FW: Outline Condition 10 (ref. P/69/26/DOC) - Land North of Sefter Road & 80 Rose Green Road, Pagham

We submitted an application to discharge Outline Condition 10 at our site Land at Sefter Road, Bognor (ref. P/69/26/DOC). This submission includes additional information to supplement the approved details, in accordance with the request from ADC.

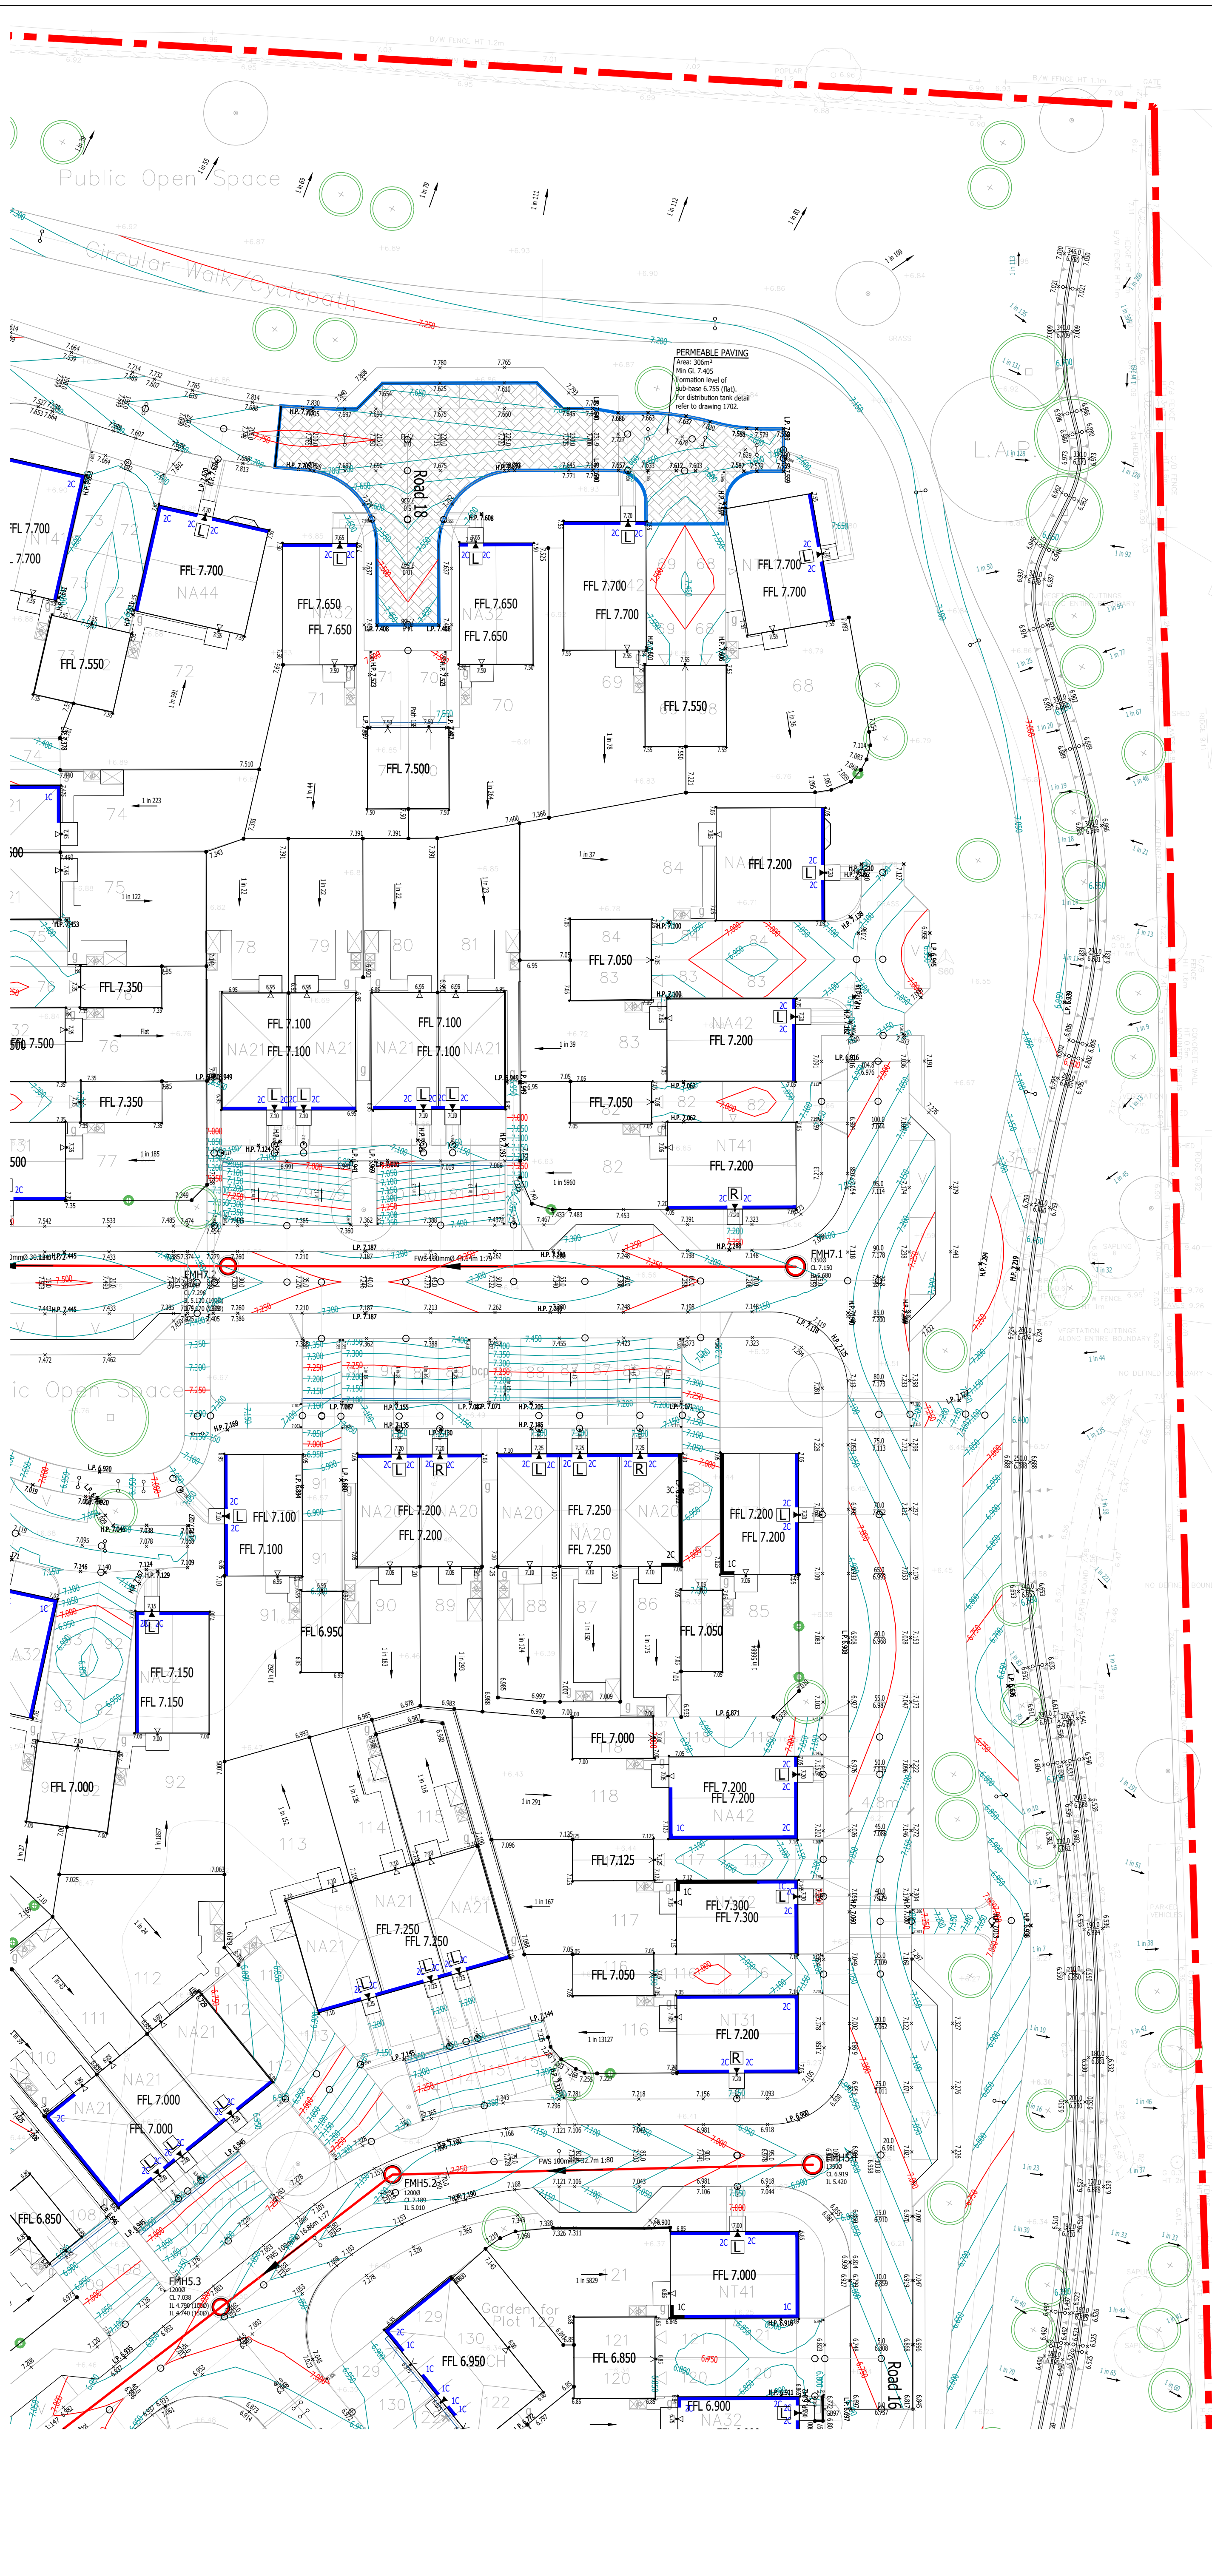
- Point 4: It is understood that the updated 2 No drawings relate to the boundary ditch/flood bund feature variations. The applicant however has not provide any summary to explain the situation for this application. This summary must clarify the variations from the approved design and clarify any issues raised by ADC following site inspections.

- Point 6: *Further to comment 4 above, it is evident that the flood bunds and swale are to provide some mitigation for exceedance flow. Further evidence is required to determine the impacts of these local catchments where this is partially footway (impermeable) and verge (greenfield run-off). This shall be quantified and re-modelled within the 1D calculations to conclude there is sufficient provision within the receiving SUDS basins/network*

The overland flow swale and bund have been redesigned to reroute any overland flow separately to the SuDS drainage system (rather than into the attenuation pond). The calculations previously provided therefore remain unchanged.

To address the neighbour's concerns regarding the potential risk of flooding to their garden, and although such a risk is considered unlikely, a ditch and bund arrangement has been incorporated along the eastern boundary as a precautionary measure. This feature is intended to manage any surface water runoff that may occur and to provide reassurance in response to the concerns raised.

The surface water run off is minimal yet as a precautionary measure to appease concerns of the neighbours abutting the site we have worked with our engineer to amend the drainage design to manage the concern. Calcs can be provided if necessary following confirmation with Paul Cann that this is a satisfactory solution following the site visit.

10768 SEFTER ROAD, BOGNOR REGIS
EXISTING OVERLAND FLOW SCALGO ANALYSIS
23/07/2026

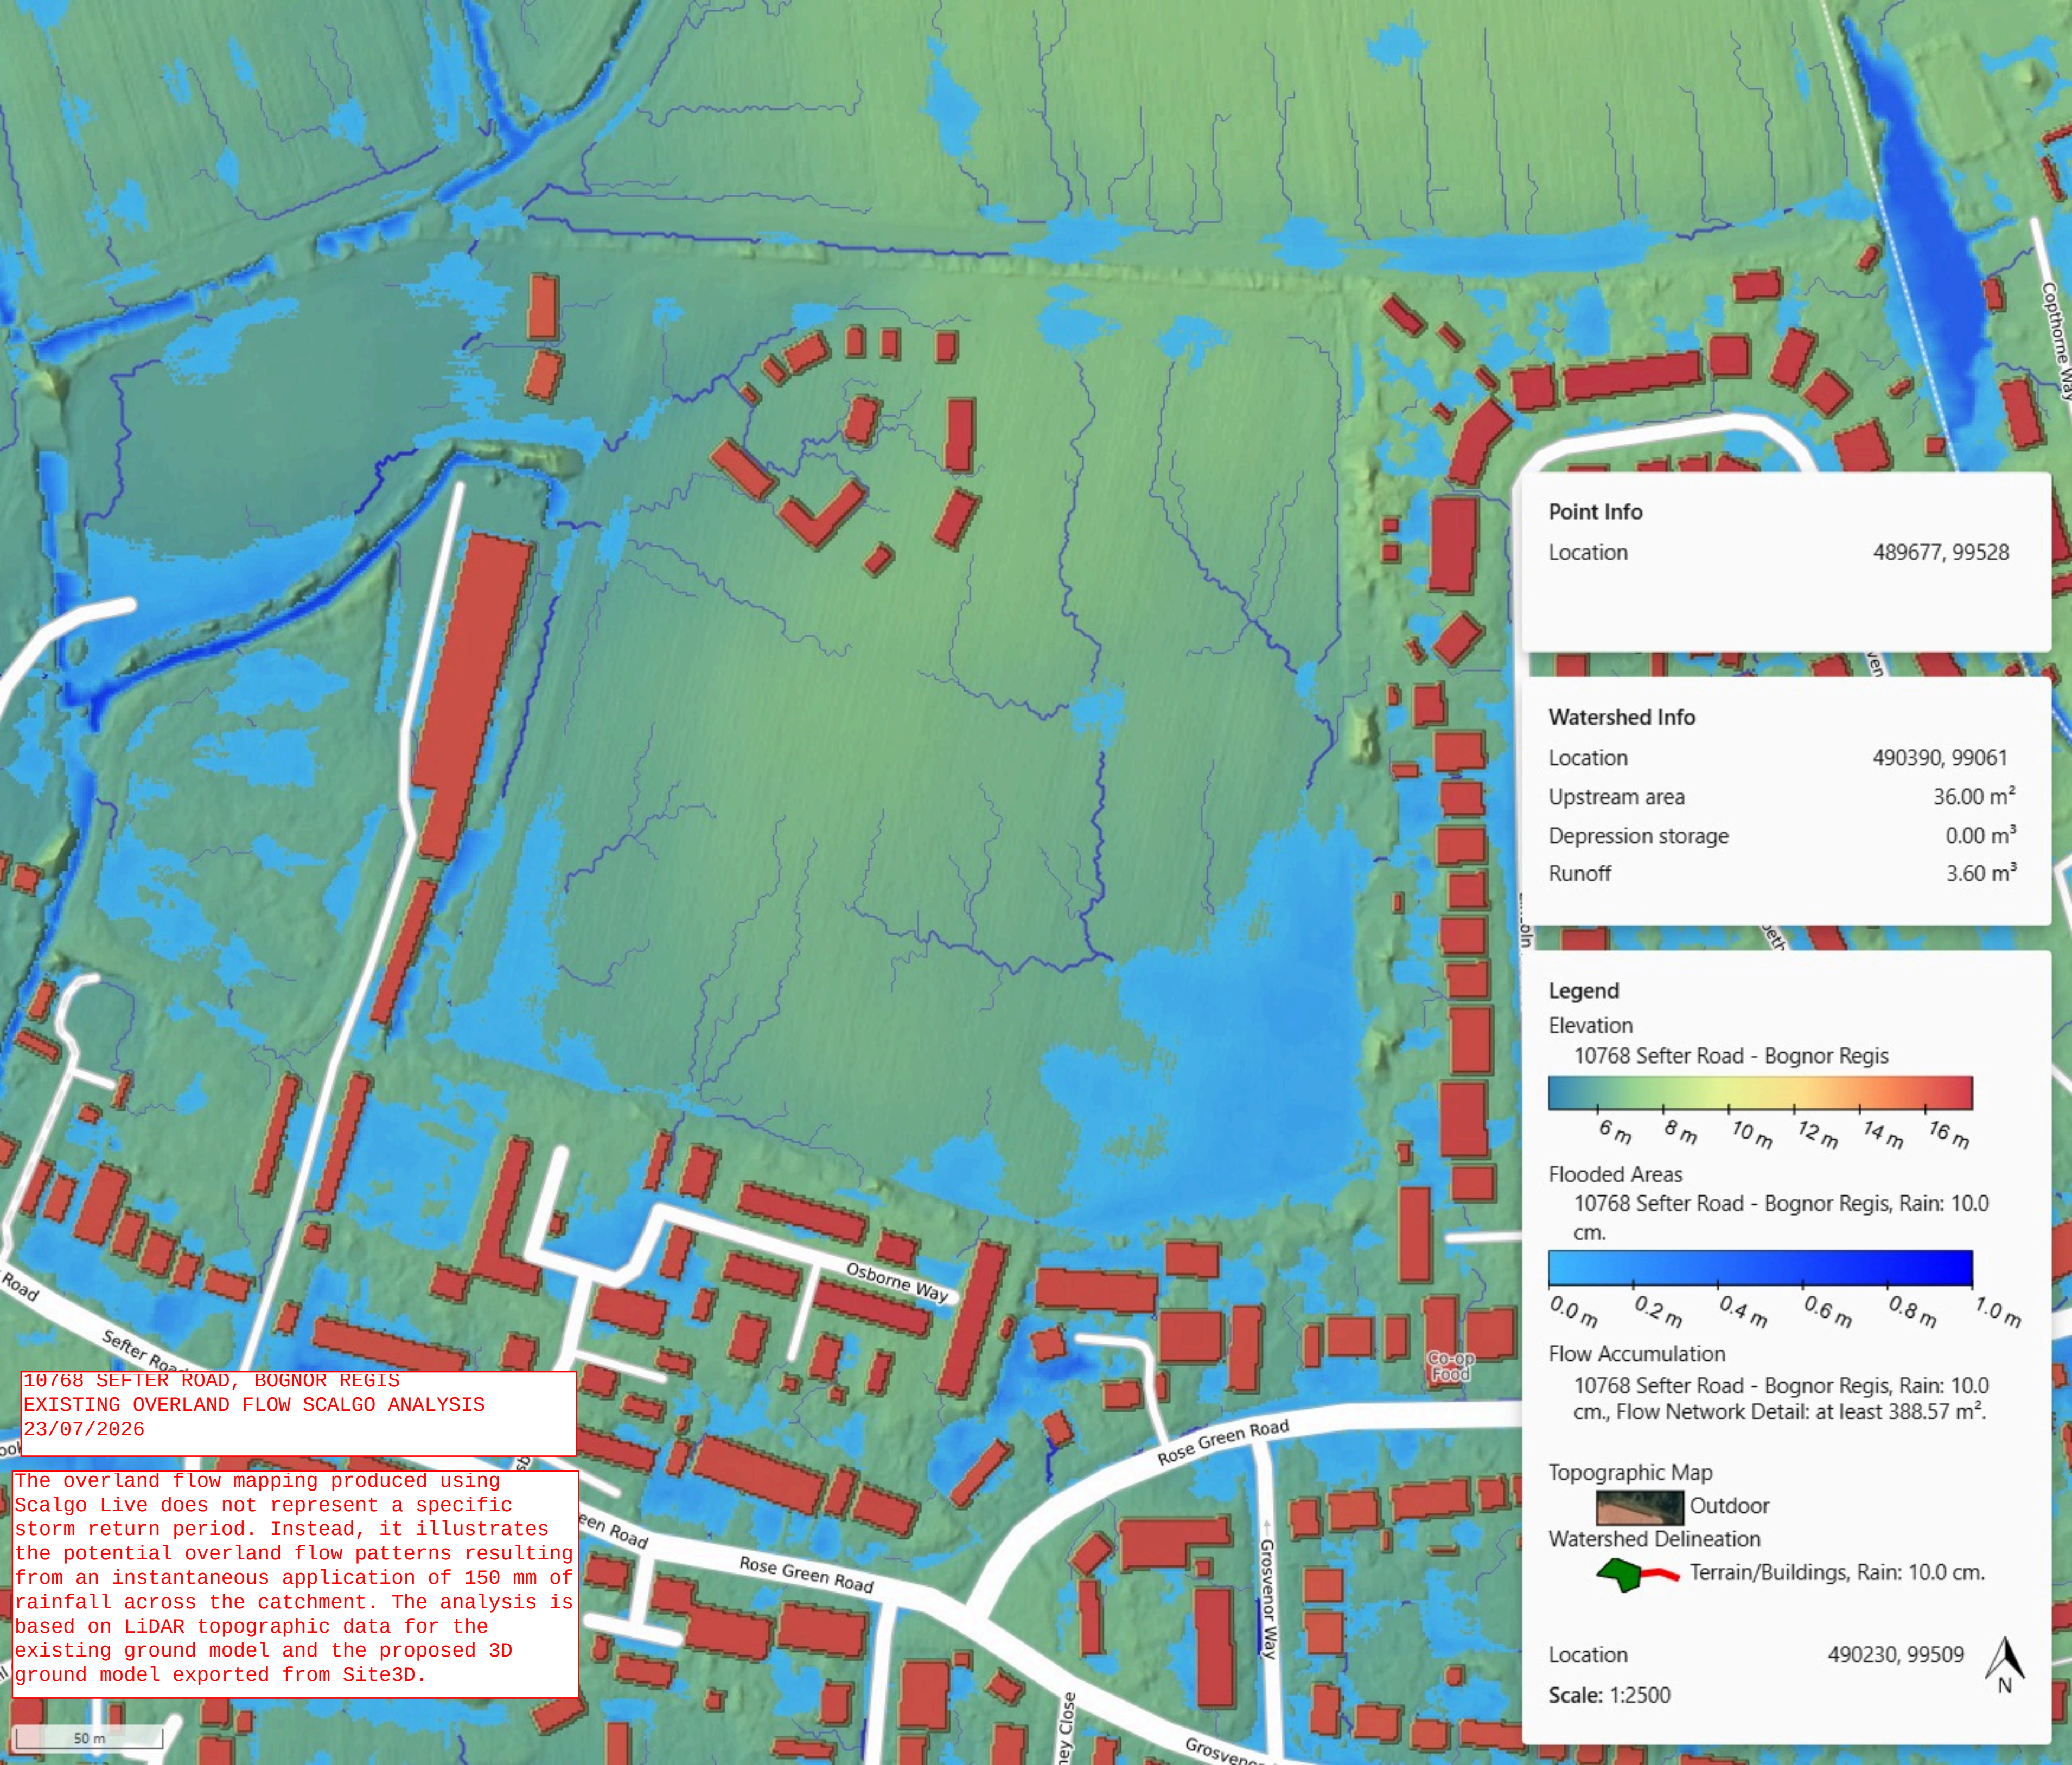
1. Please can the application provide a mark-up to evidence the approximate exceedance flow risk and estimation of the catchment and run-off volumes (greenfield)
2. Can the 1D modelling be re-run to include the estimated area or a suitable uplift value to conclude if there are any residual breach risks.

We have included outputs from SCALGO to demonstrate exceedance flow route. This illustrates the potential overland flow patterns resulting from an instantaneous application of 150 mm of rainfall across the catchment. The analysis is based on LiDAR topographic data for the existing ground model and the proposed 3D ground model exported from Site3D. This demonstrates that exceedance flows from the site will be routed southwards in line with the existing overland flow routes (pre-development), with no flows entering the adjacent site.
